Tel: 01903 737756
Email: planning@arun.gov.uk
www.arun.gov.uk/planning
Please ask for: Ms Ella Summerfield
Email: ella.summerfield@terraquest.co.uk
Telephone: 0121 2341390
Our Ref: CM/21/26/L
Your Ref:
Date: 24th August 2026

Listed Building Consent for Alterations, Extension or Demolition of a Listed Building

Development: Replacement of existing windows (7 no. in total) plus 1 no. exterior door with identical style.

Location: Kents Farm House Brookpit Lane Climping BN17 5QU

Revisions	
A	Revisions
© copyright	
Client: T AND S JACKSON	
Job Title: KENTS FARM HOUSE CLIMPING WEST SUSSEX BN17 5OU	
Drawing Title: ELEVATIONS MAIN HOUSE PROPOSED	
1:50 @ A0	
D OCT 2020	Drawn by MJW
Drawn by	Rev.
112/168/5

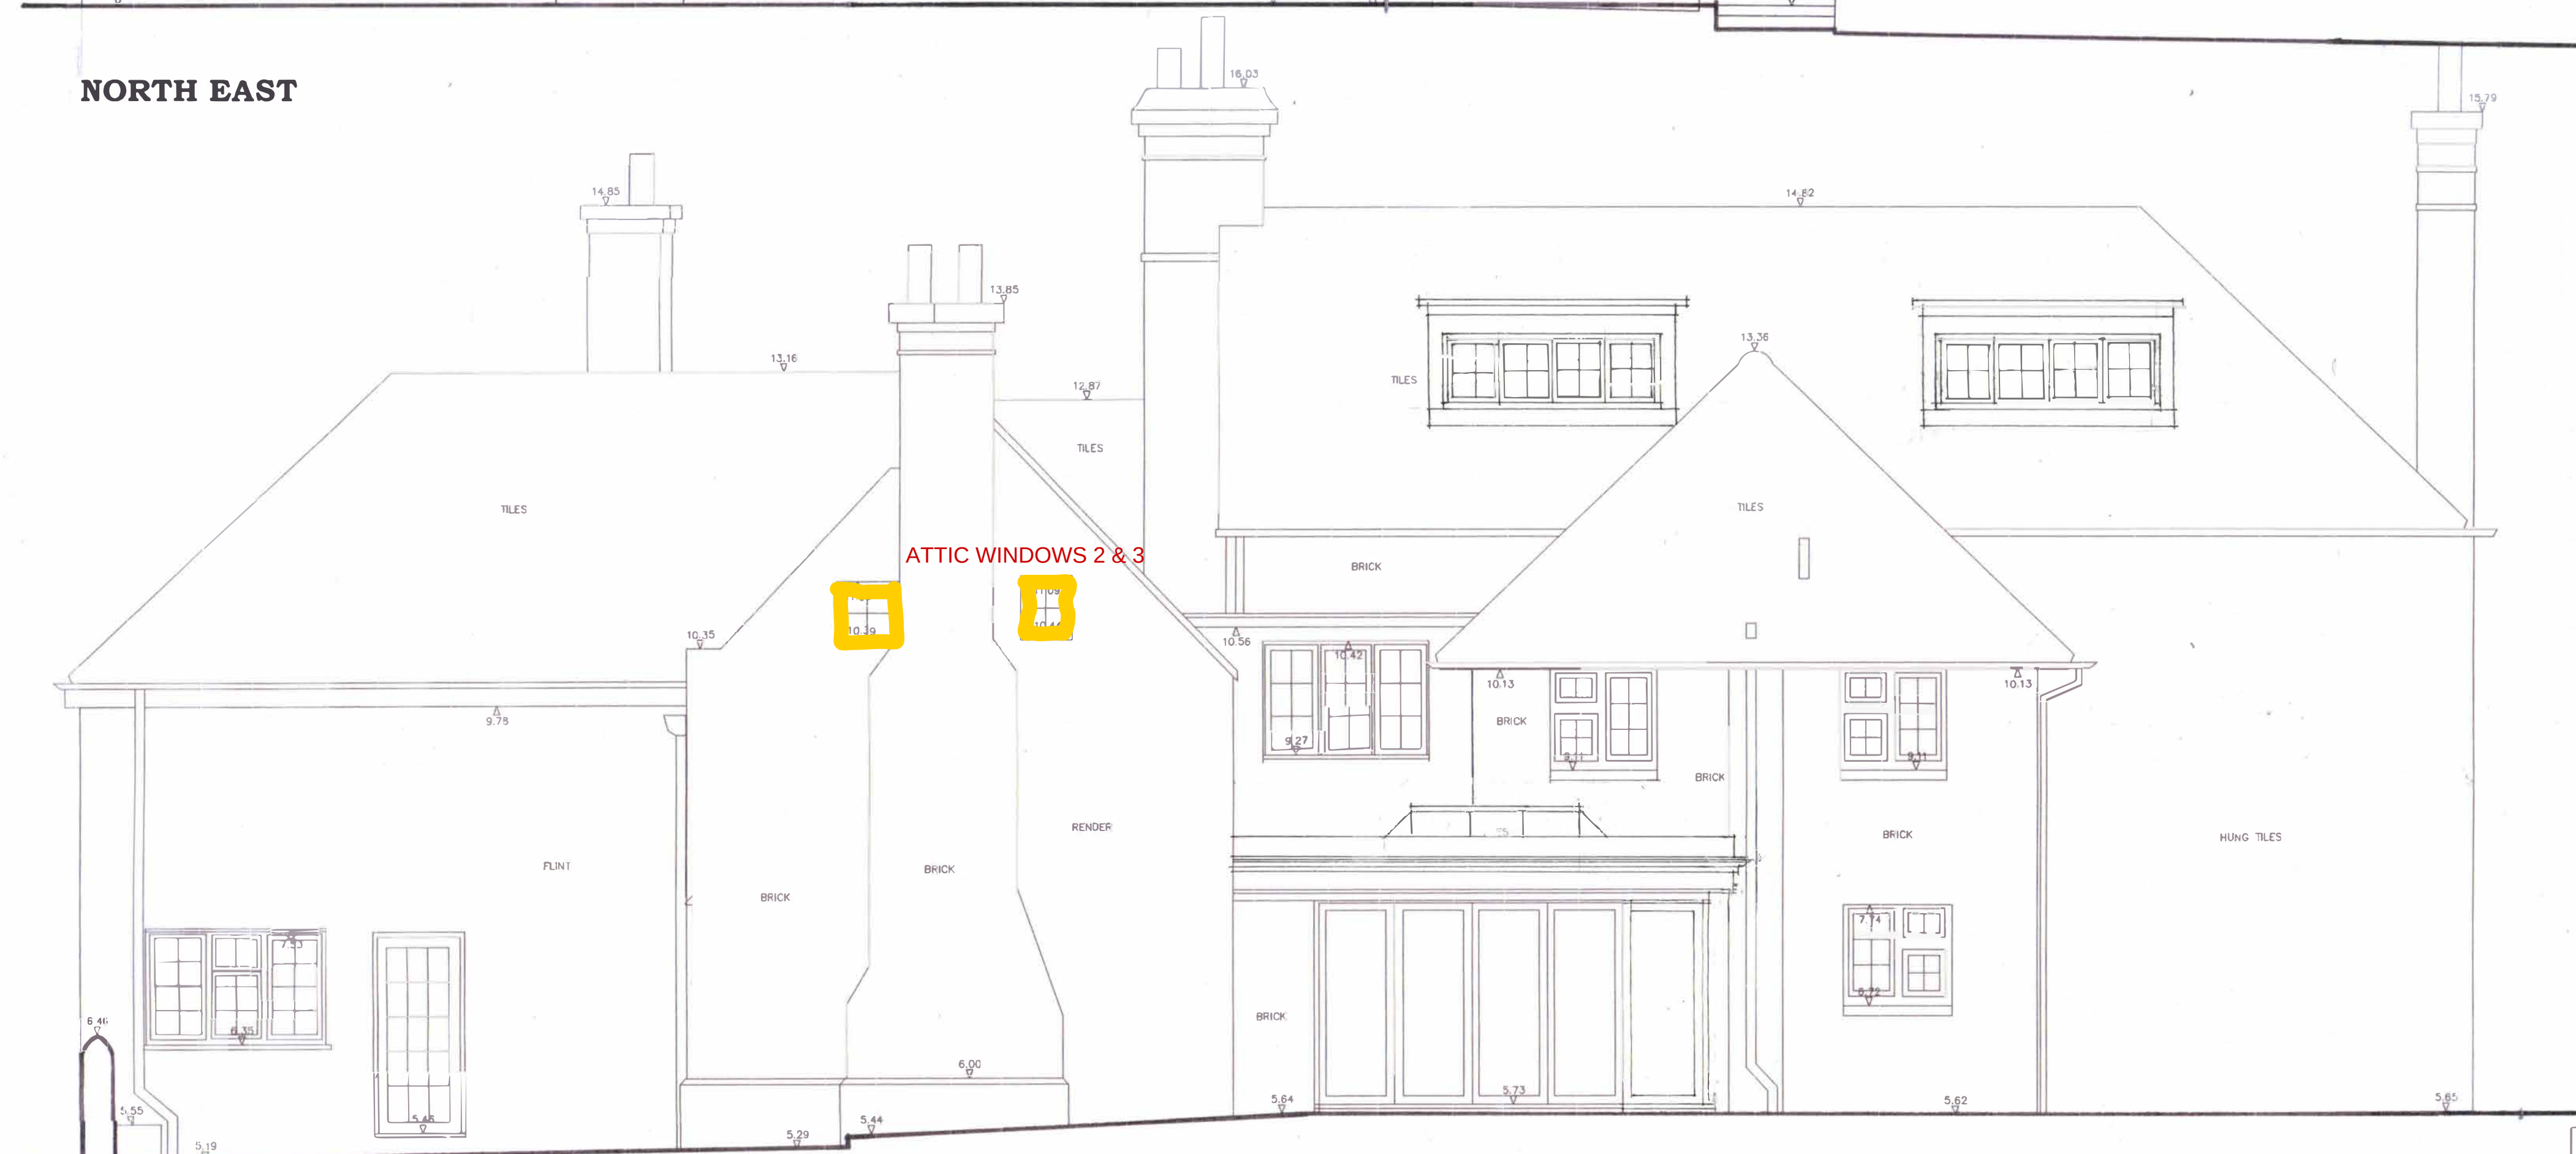
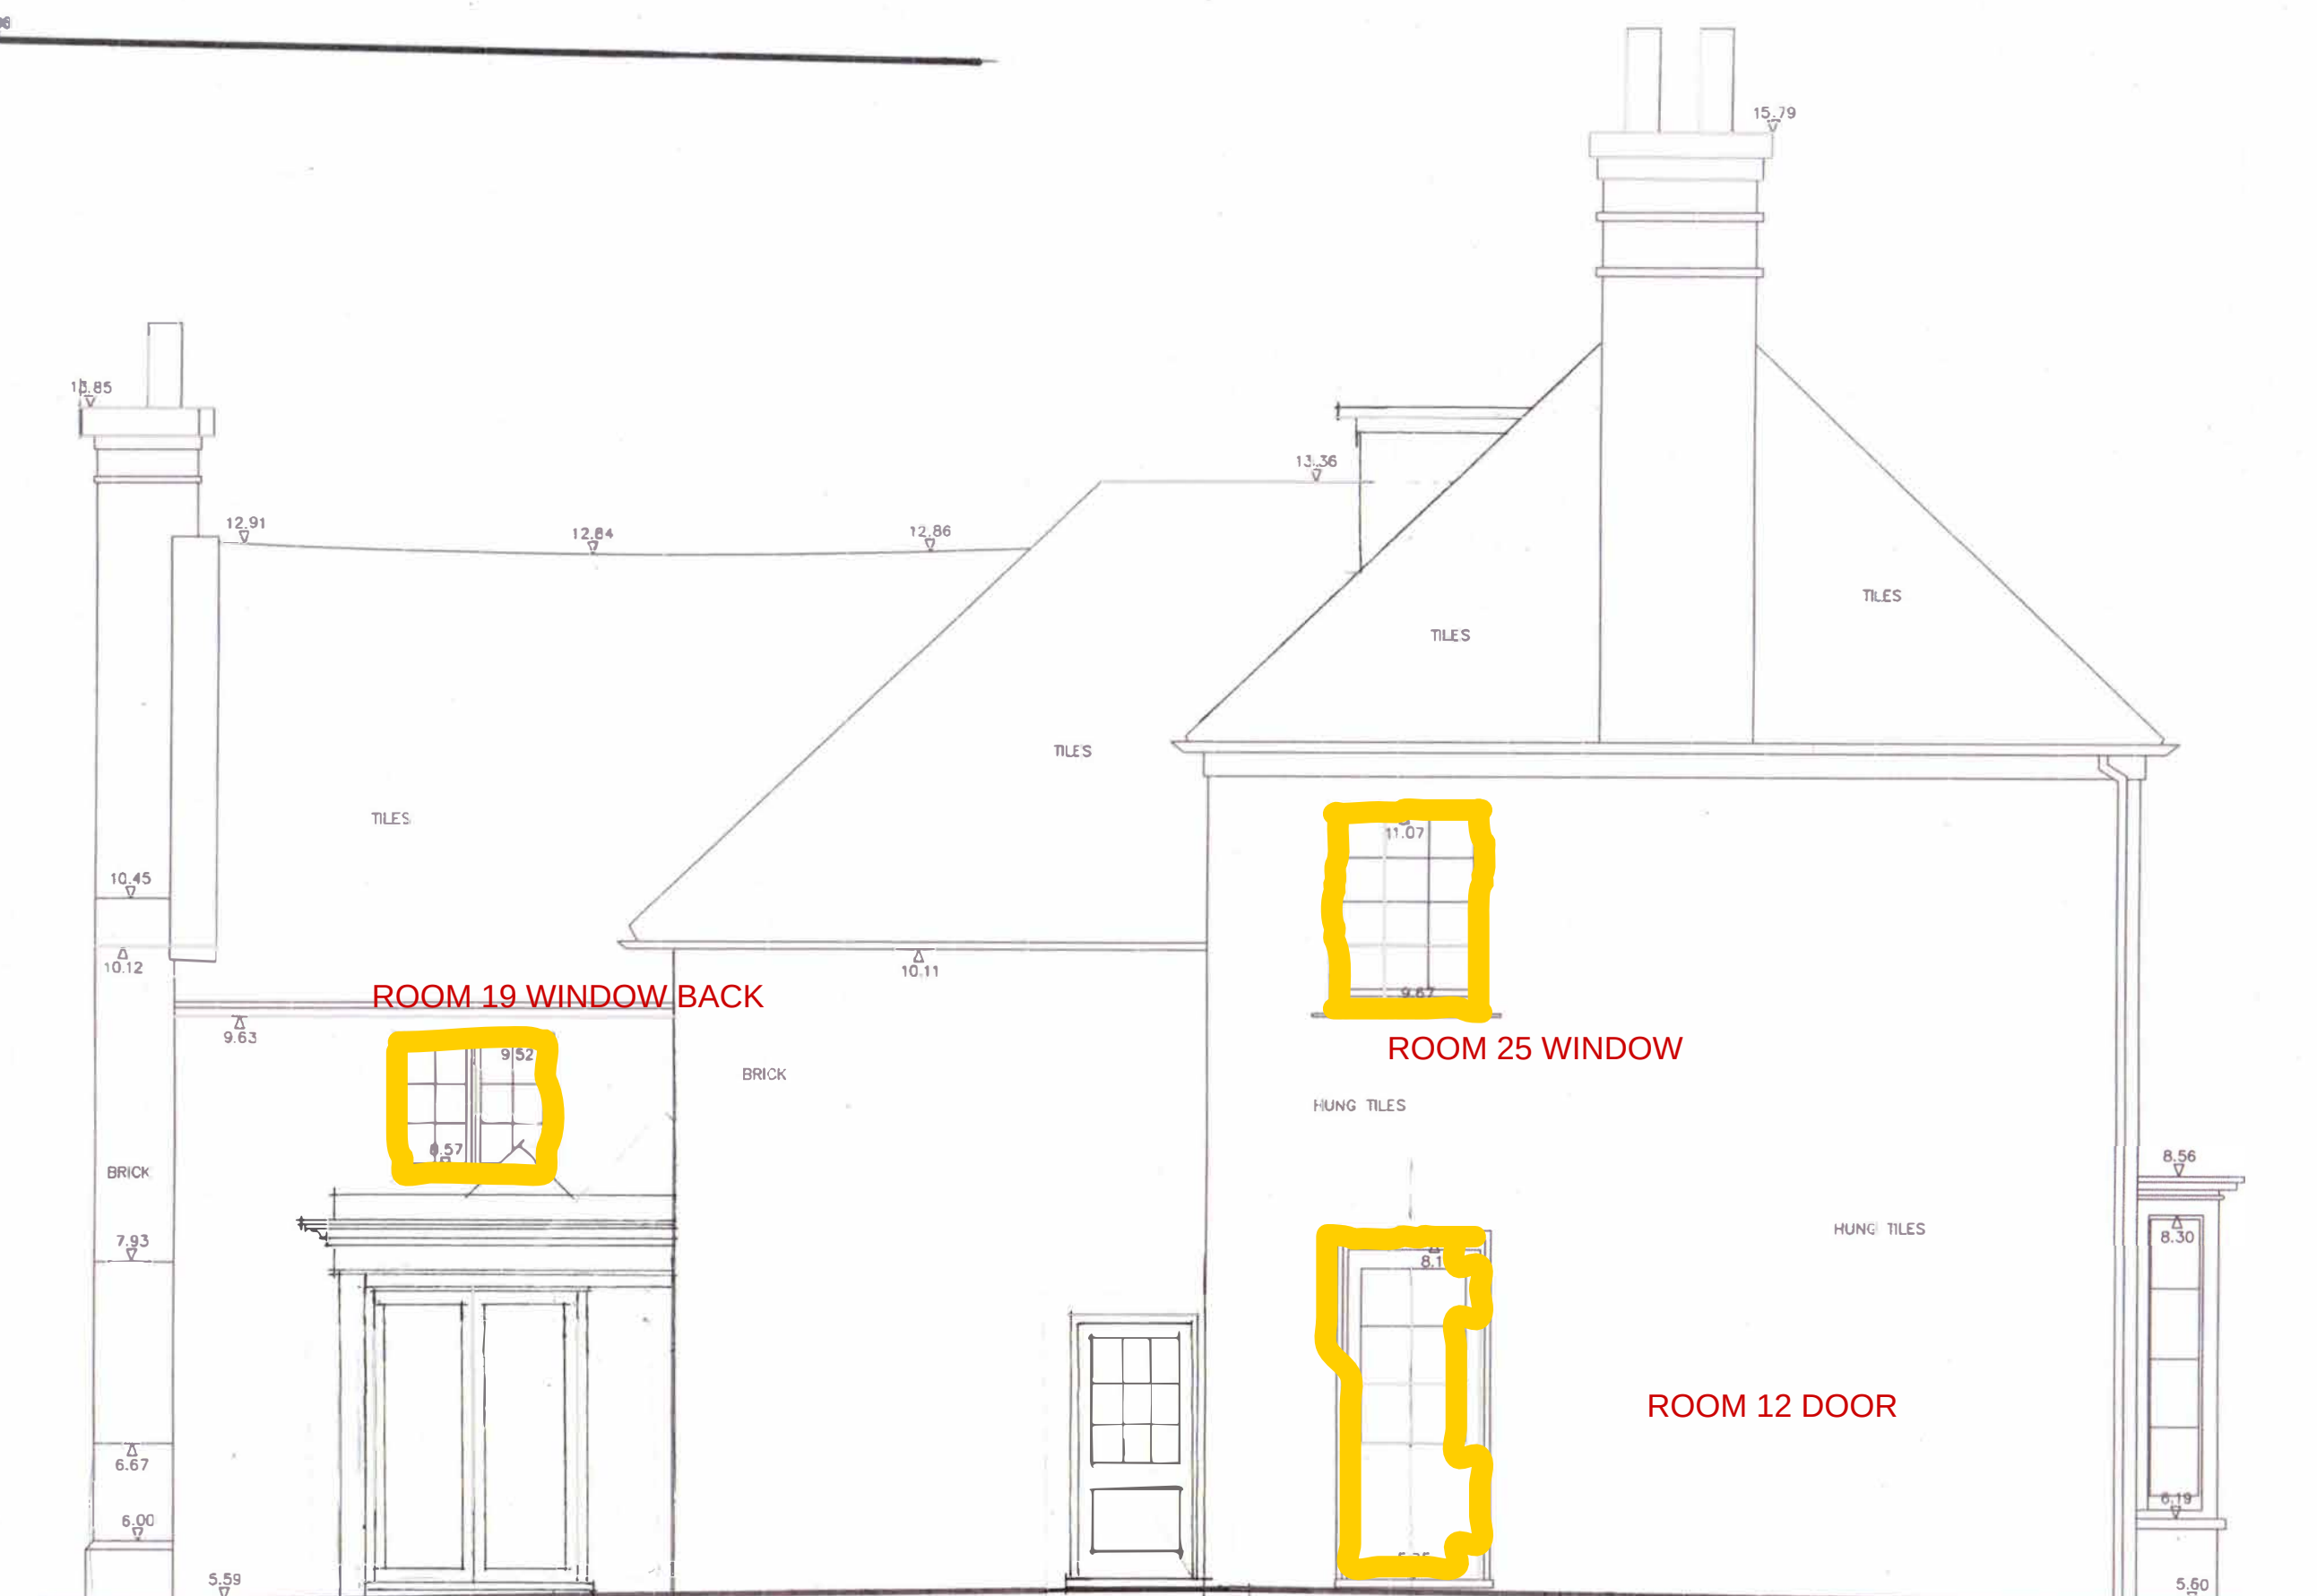
The proposed elevation plan scale bar appears to be inaccurate to the provided scale, please review.
